FORMAL COMMUNITY SUBMISSION OF OBJECTION

Application Ref: Mixed Use Development (with In-fill Affordable Housing) – 138 Maroubra Road (SSD-81426710)

Impacted Stakeholders: Adjoining Residents and Senior Citizens of the Maroubra Pacific Square Precinct

1 12 NOON - JUNE 21st
1 : 500

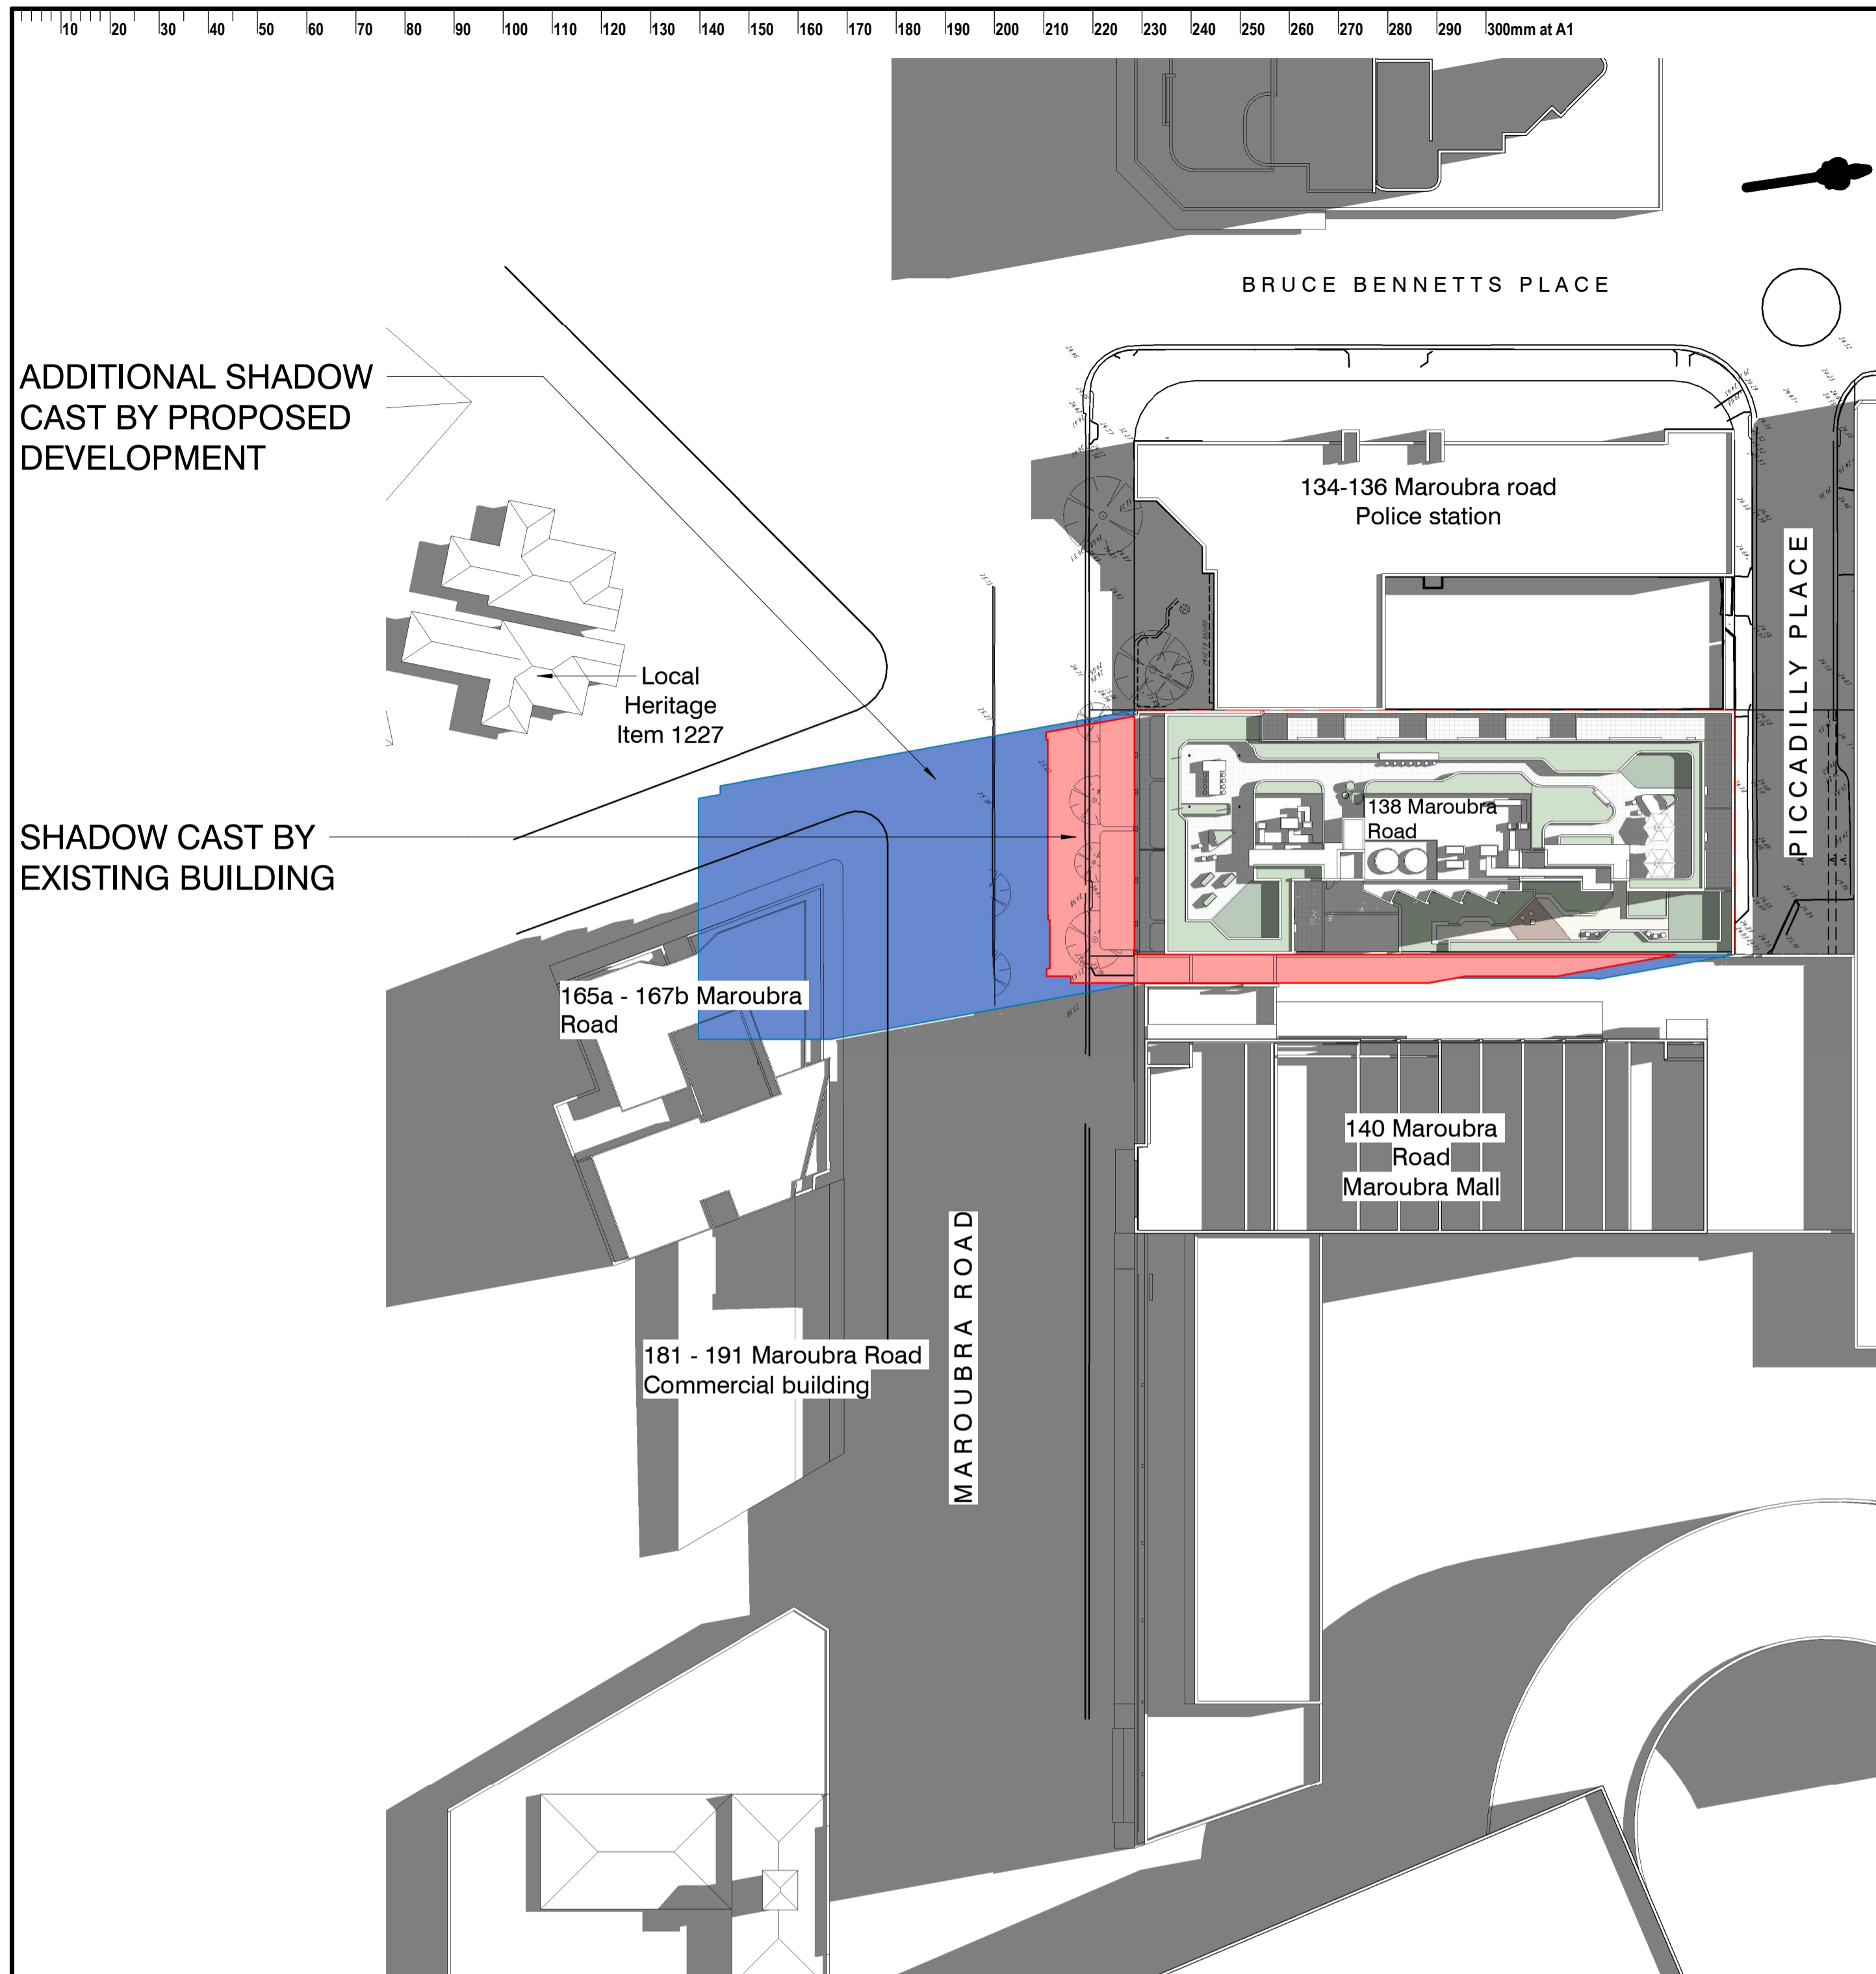
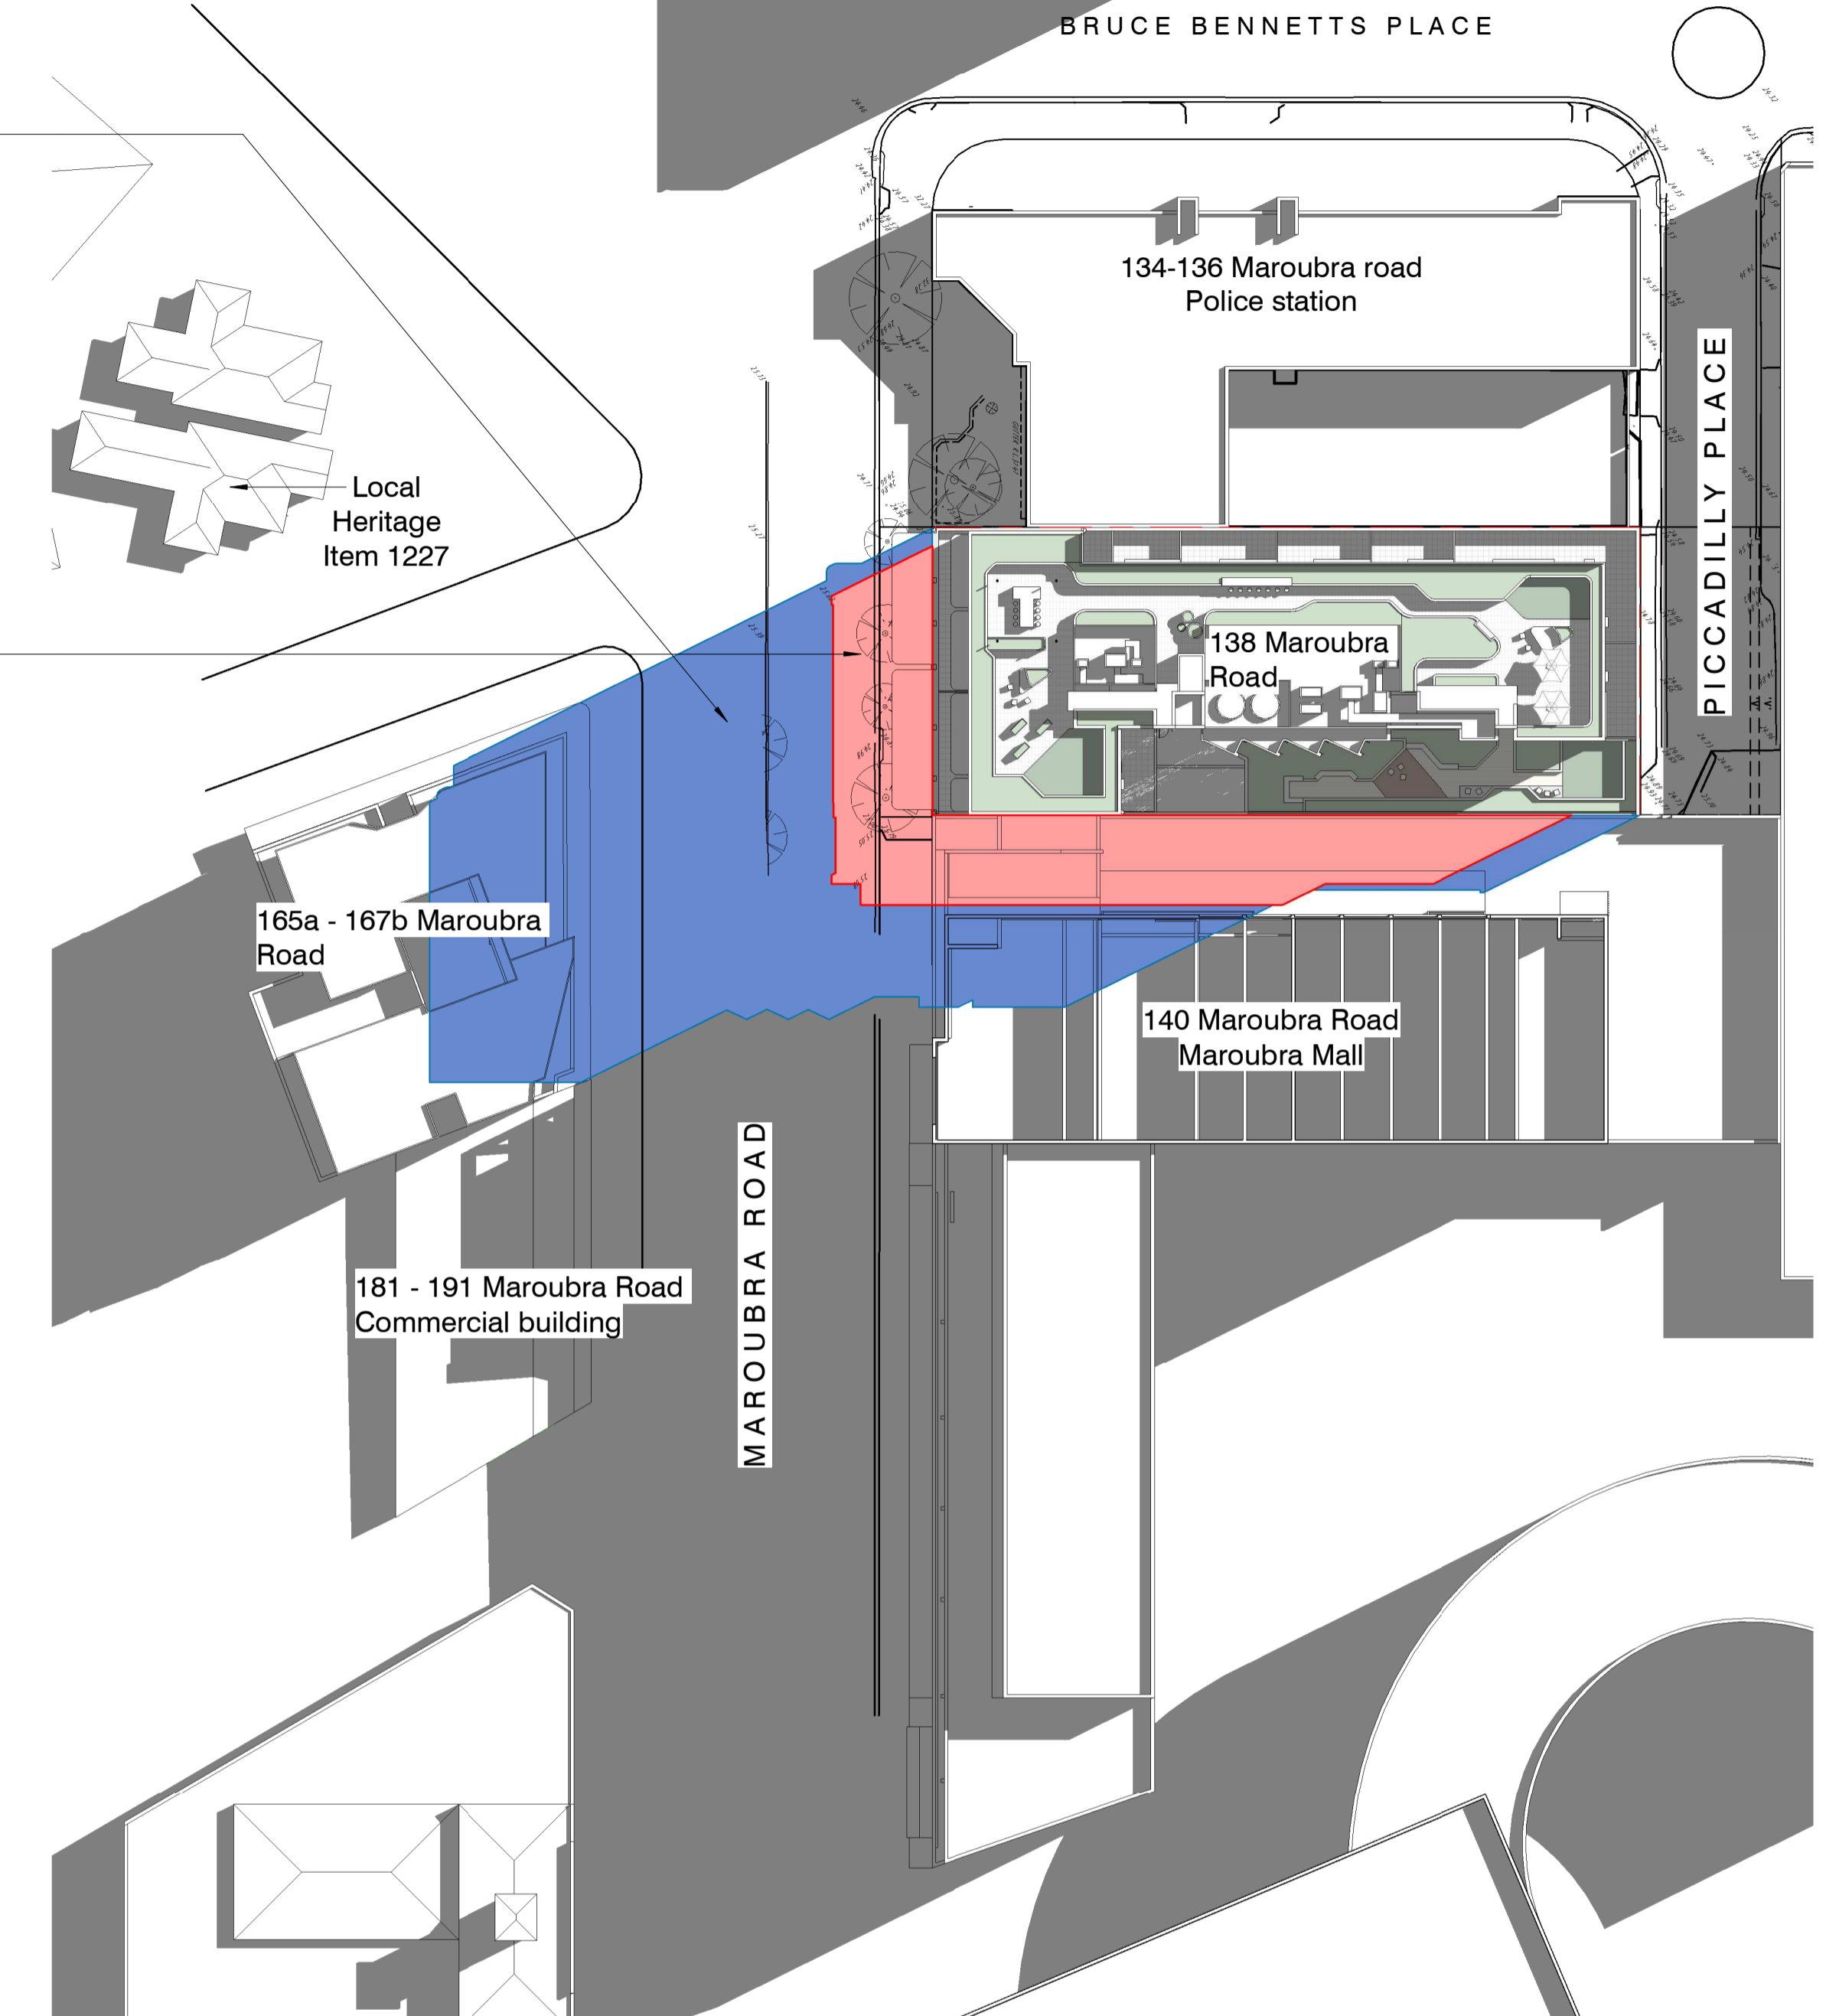
The submitted shadow modeling relies on generic, regional guidelines under the Apartment Design Guide (ADG), completely ignoring the specific microclimatic reality of the surrounding residences. Building a deep, vertical 10-storey structure directly to the west completely cuts off crucial afternoon daylight.

Natural sunlight is an essential requirement for the health, well-being, and internal apartment heating of elderly residents, many of whom suffer from limited mobility and remain indoors. Depriving these living spaces of essential afternoon light hours early creates cold, dark internal environments that directly degrade the daily health and comfort of our senior community.
